CITY OF PORTLAND, MAINE
HISTORIC PRESERVATION COMMITTEE

61-C-13
October 17, 2000

Re: 309 Spring Street: Certificate of Appropriateness for modifications to a previously approved porch addition.

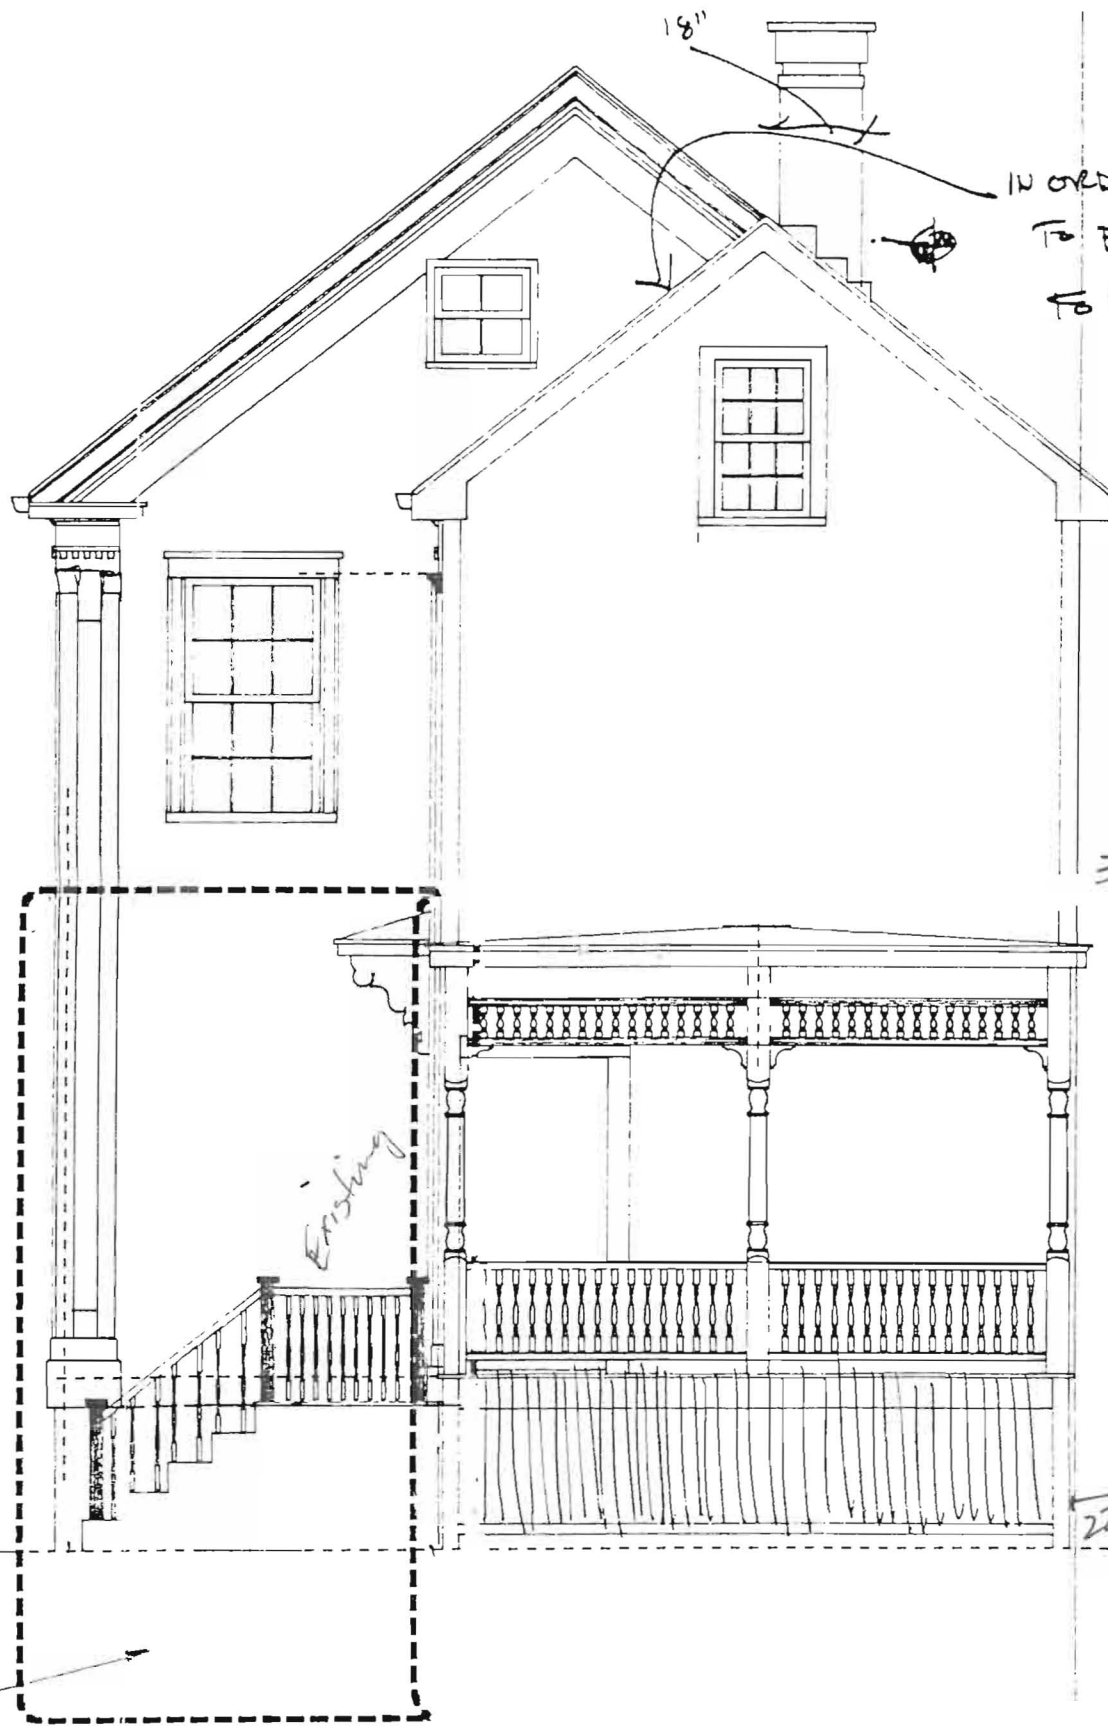
- i. That the posts supporting the second story deck be substituted with a chamfered square posts to be comprised of a 4"x4" post wrapped with 3/4" trim stock;
- ii. That a framing section be provided for historic preservation staff review and approval which reflects a Greek revival retro-fit of the existing second story deck/ roof cornice interface;
- iii. That spacing of railing balusters be adjusted to 2 3/8" clear;
- iv. That complete construction drawings be provided to Historic Preservation staff for review and approval; and,
- v. That the applicant apply to code enforcement for an exemption from building code railing height requirements for the top railing (siting Historic Preservation Standard #9 - compatibility of contemporary structures.)
